ENG-PUDSP19005-R4-GEC-Redlines Summary

ENG-PUDSP19005-R4-CD-Redlines Summary_Markup Summary

CARRIAGE MEADOWS SOUTH AT LORSON RANCH FIL. NO. 2 GRADING AND EROSION CONTROL PLAN

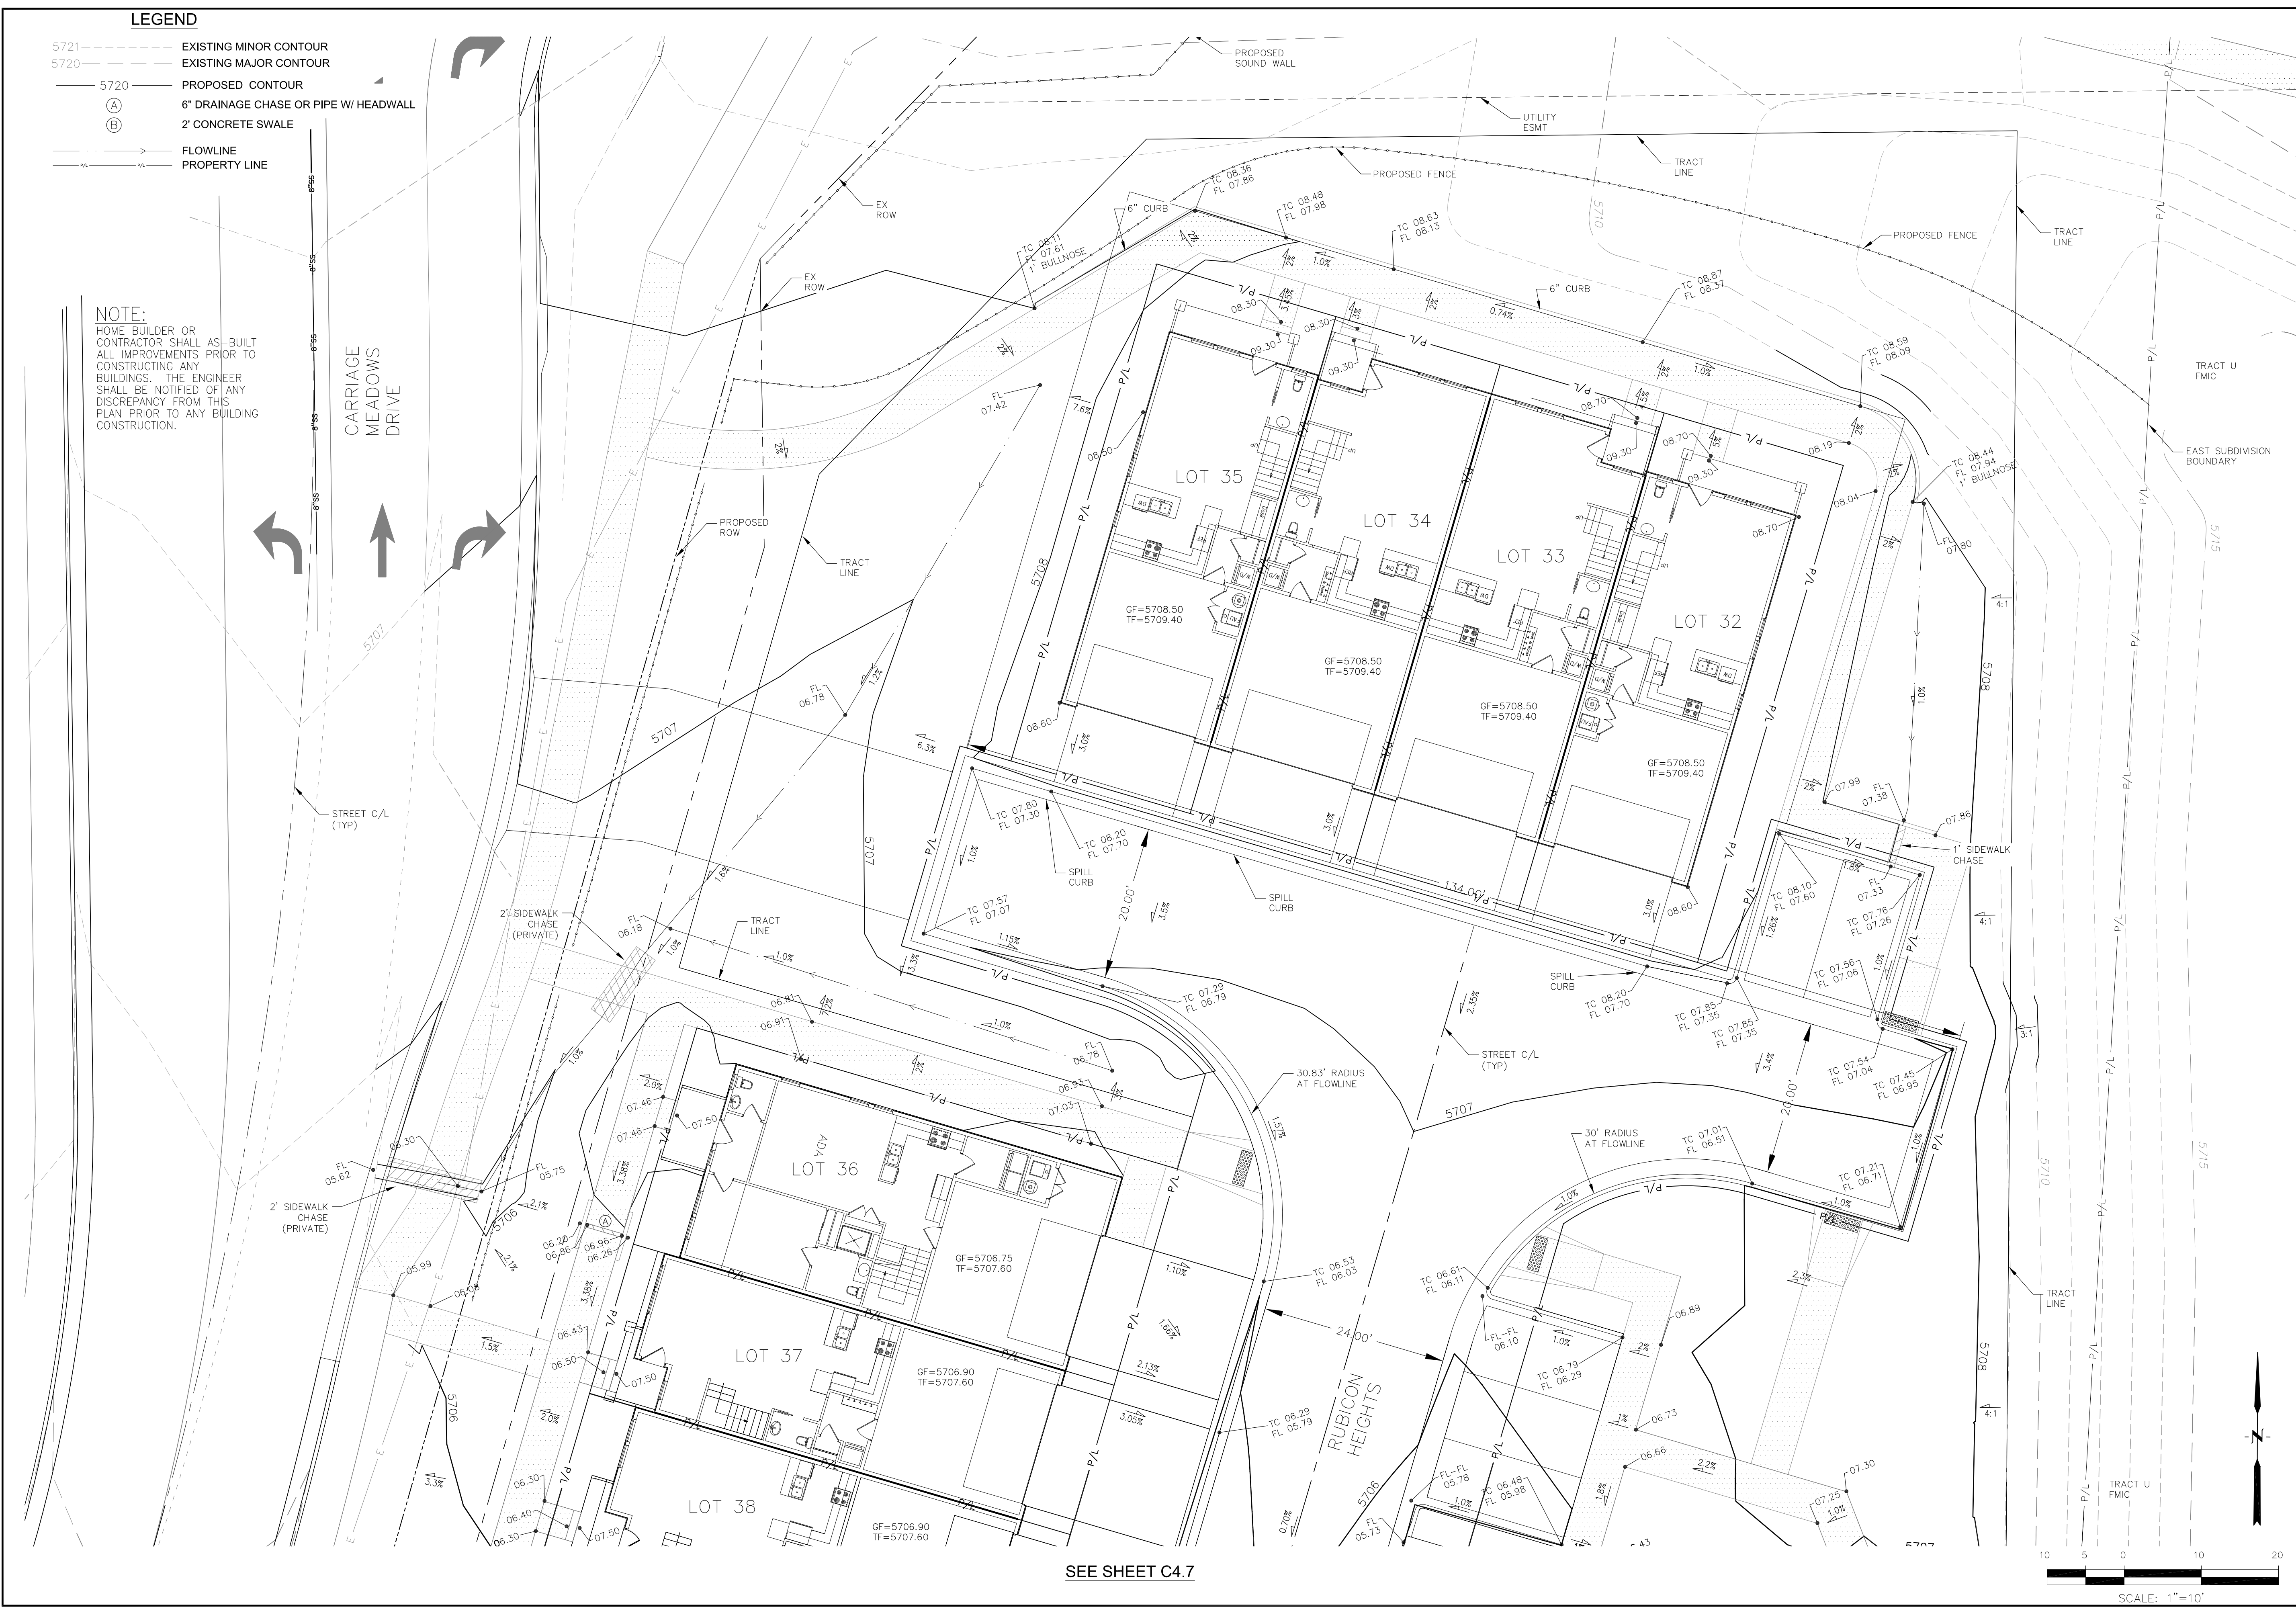
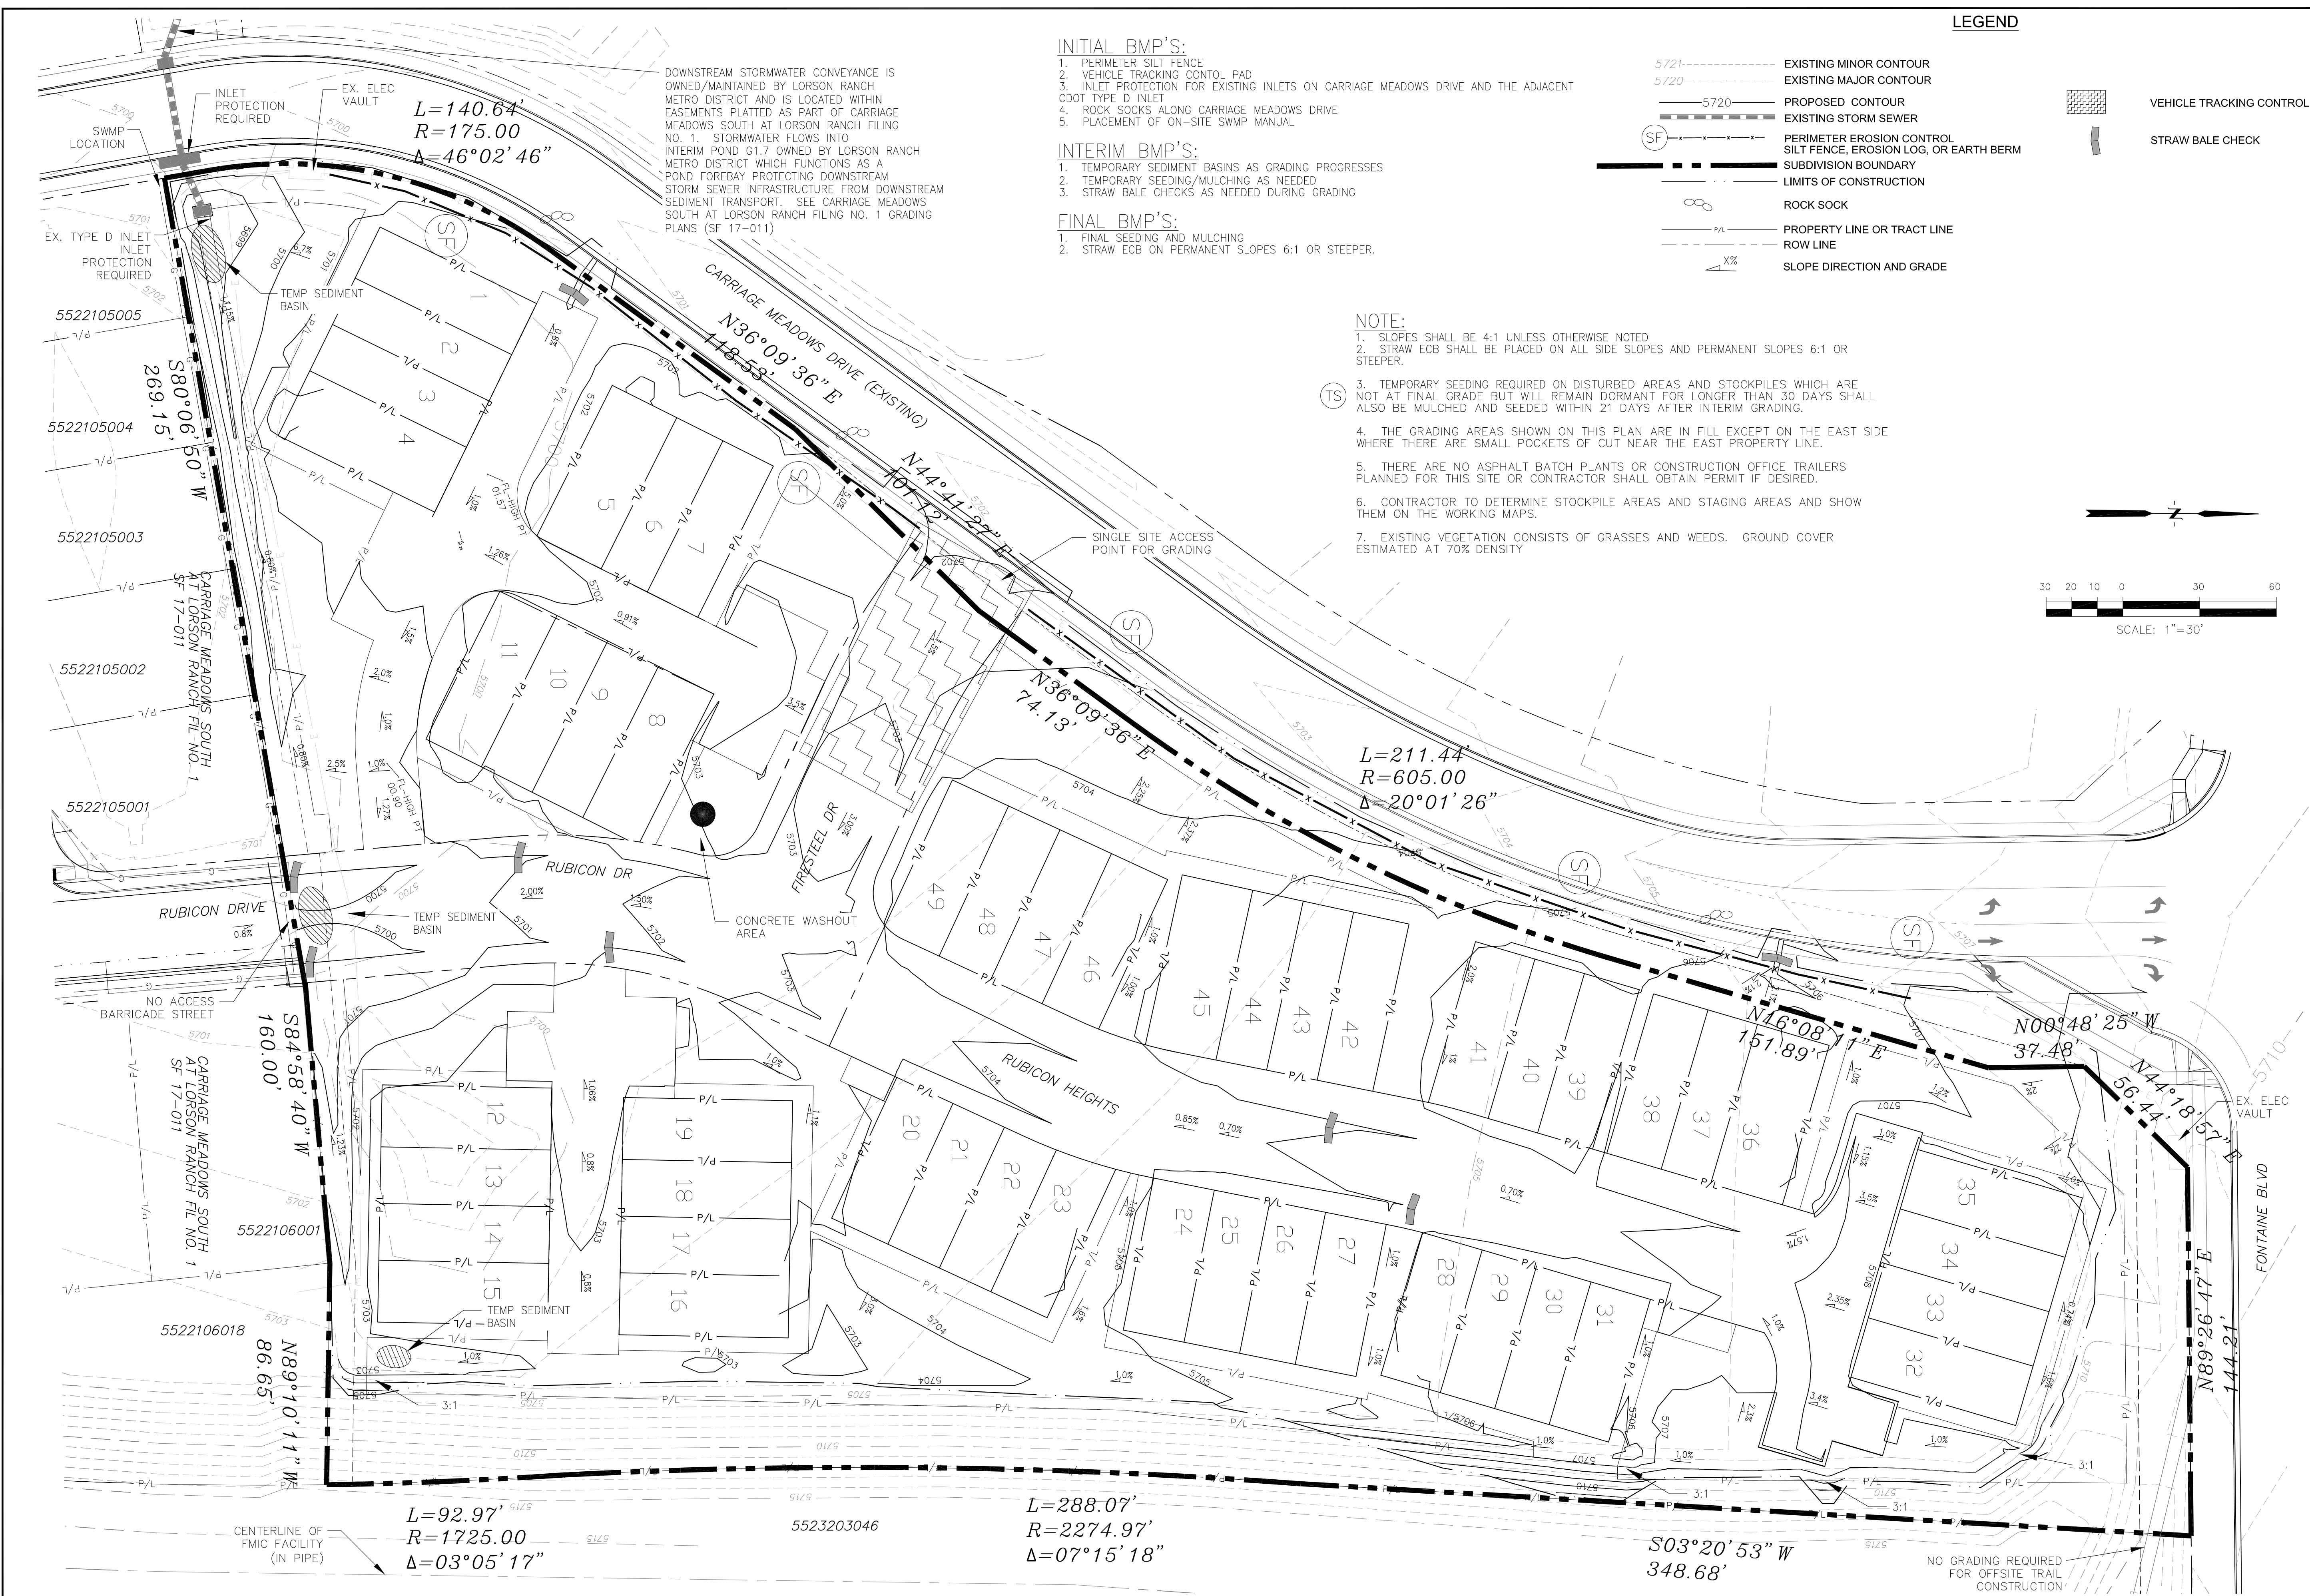
Call out / describe downstream conveyance(s), easements, and control measure(s) and that these are under the control of/maintenance by the developer.

RS / Rock Sock? (per detail provided)

Label construction ingress/egress and if this is the only one.

Add note per comment on checklist that all areas are fill except for cut into slope on east side. (or label on plan)

Add note that there are no batch plants or construction office trailers (or permit will be obtained.)

Add note that the contractor is to determine stockpile and staging areas and show them on the working map.

doesn't match plan

label no construction access, construction fence or barricade...
